COUNTY FILE NO. PPR-18-028

UTE PASS STORAGE FACILITY
8715 N HIGHWAY 24
CASCADE, CO 80804
EL PASO COUNTY, COLORADO

1 of 5
SITE PLAN

Markup Summary

1 SITE PLAN
SCALE: 1"=30'-0"

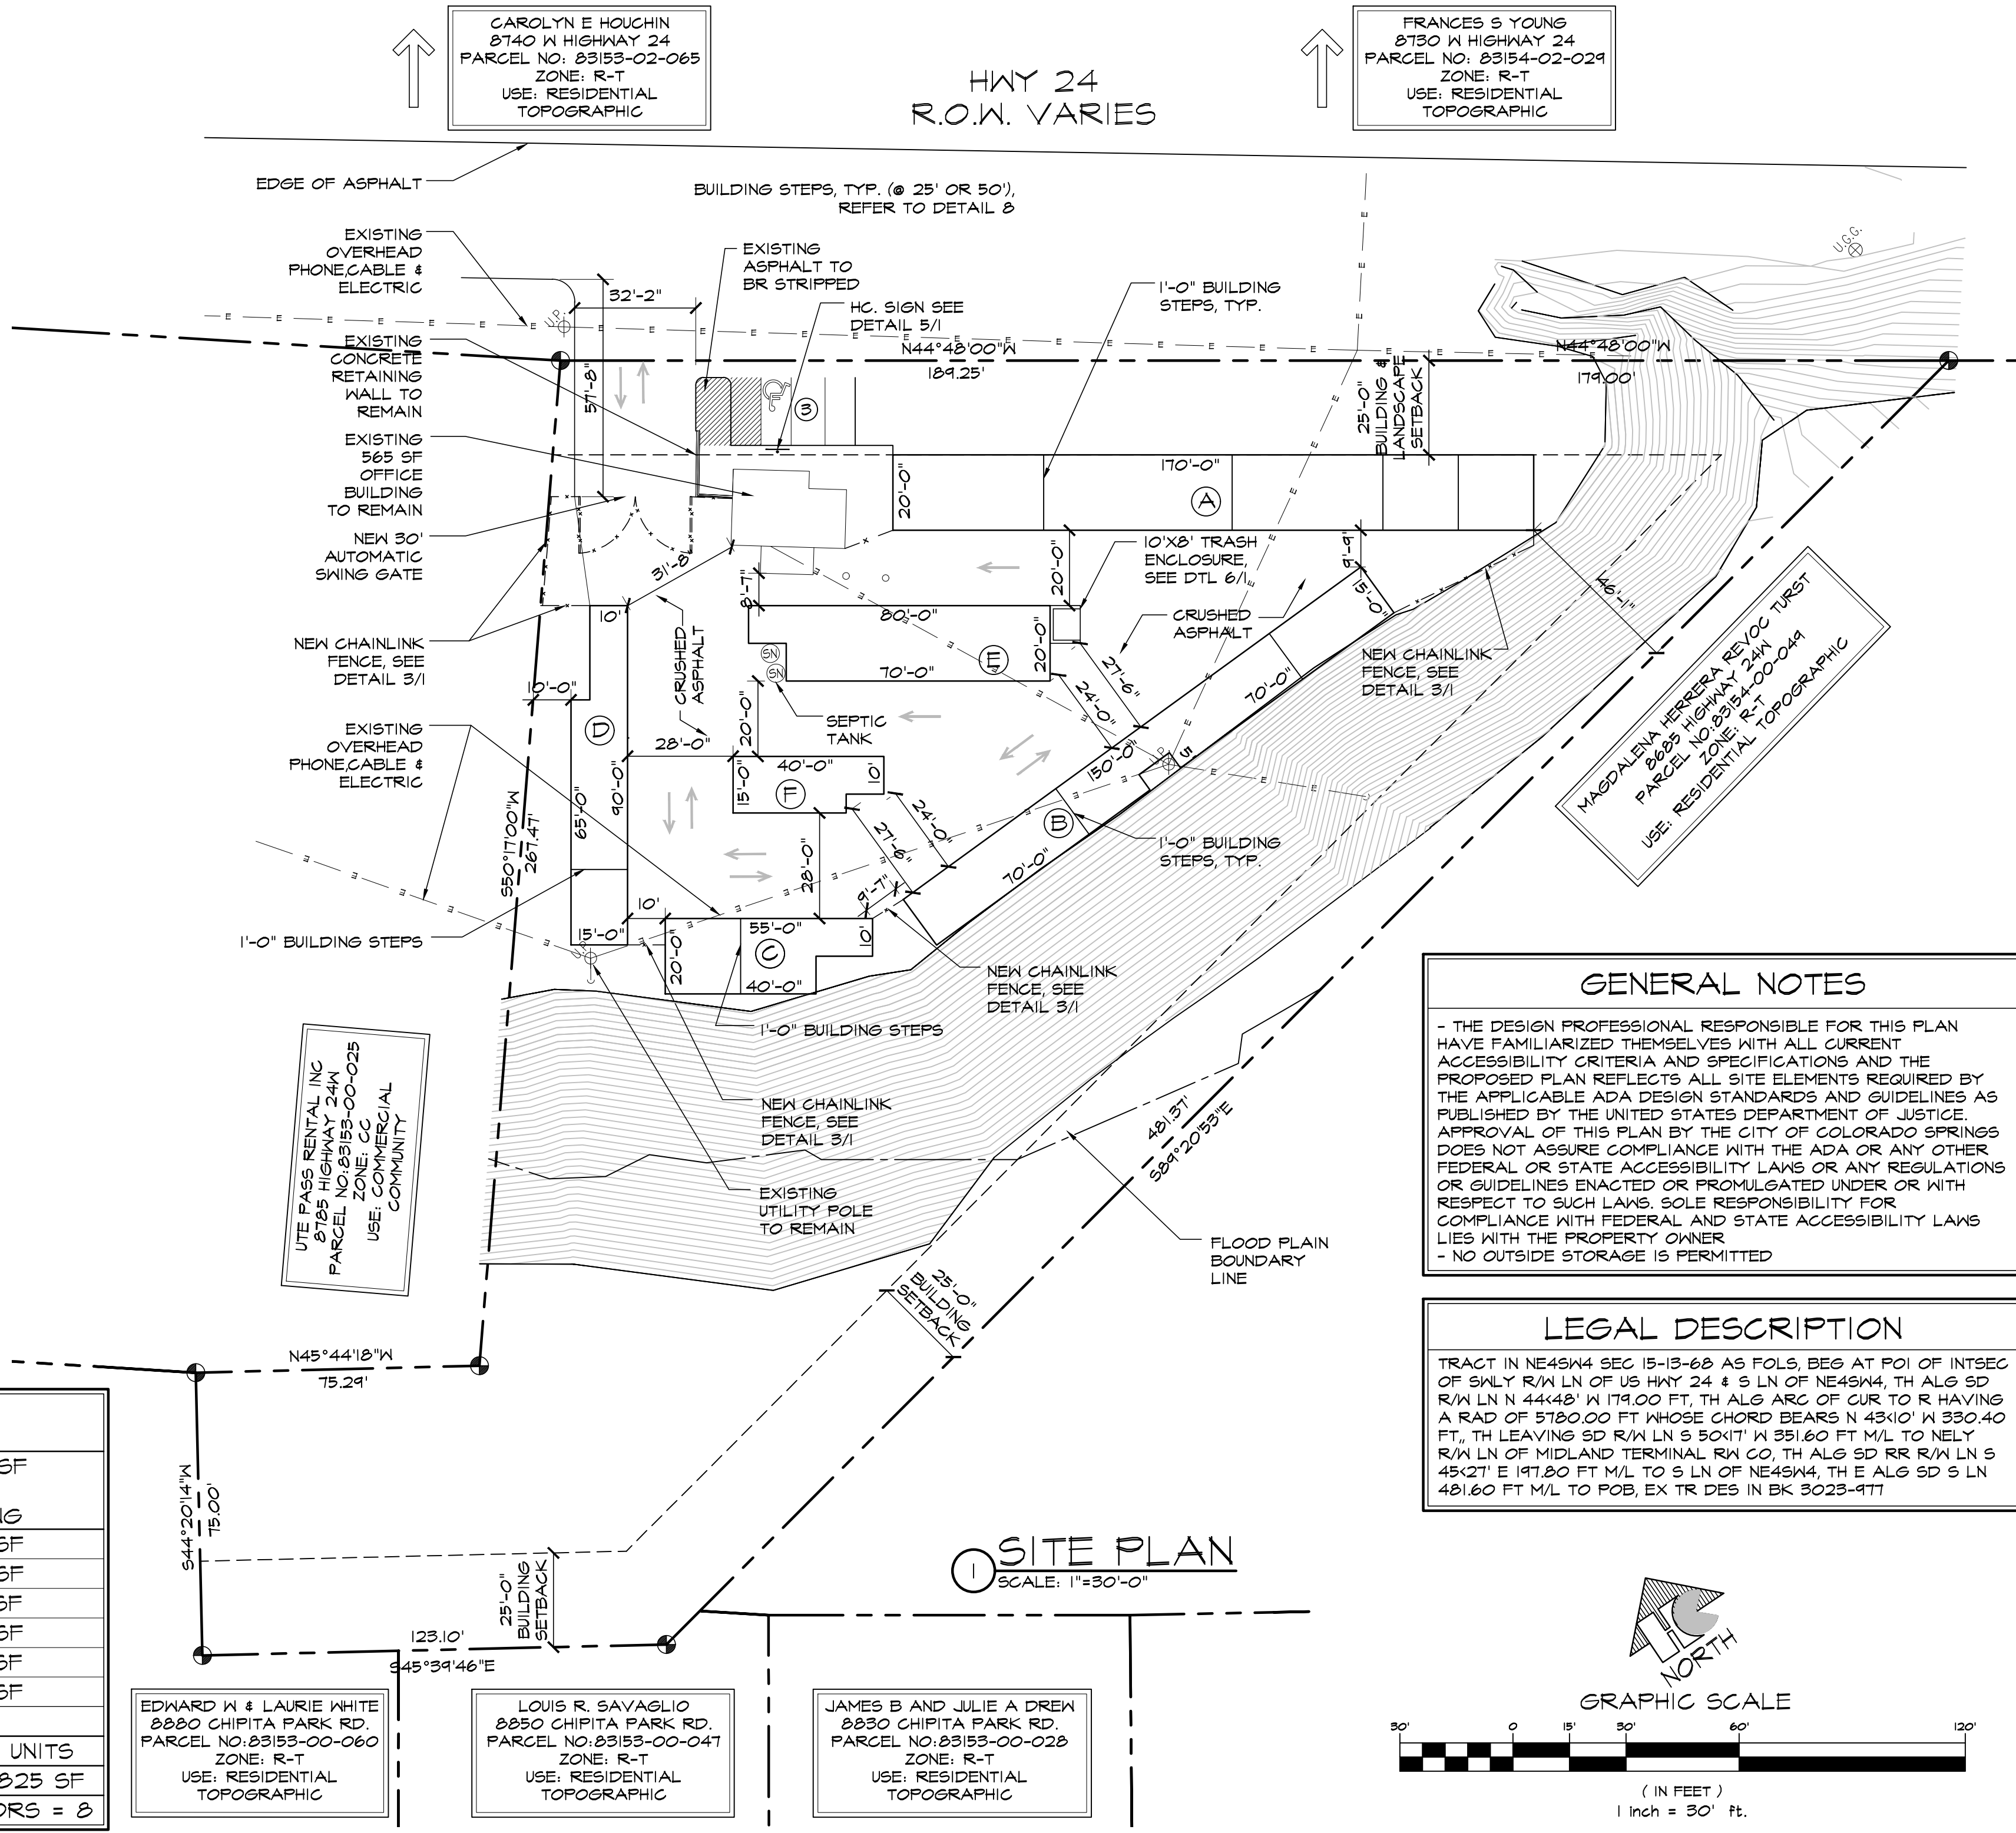
Comment not Addressed:
Is there a trash enclosure anticipated for this site? Any commercial site that can produce trash or refuse is required to have a trash receptacle, please indicate location on plan with a call out for the enclosure. Any outside storage areas must be marked, if none are proposed please include on letter of intent and a note on site plan, that no outside storage is permitted.

The drainage report from the first submittal shows an existing building around this location. Show that existing building as to be removed.

Is this line the existing C&G along Hwy 24? If so, please label as such.

Access to these units not addressed.

Comment not Addressed:
Is there a trash enclosure anticipated for this site? Any commercial site that can produce trash or refuse is required to have a trash respectable, please indicate location on plan with a call out for the enclosure. Any outside storage areas must be marked, if none are proposed please include on letter of intent and a note on site plan, that no outside storage is permitted.
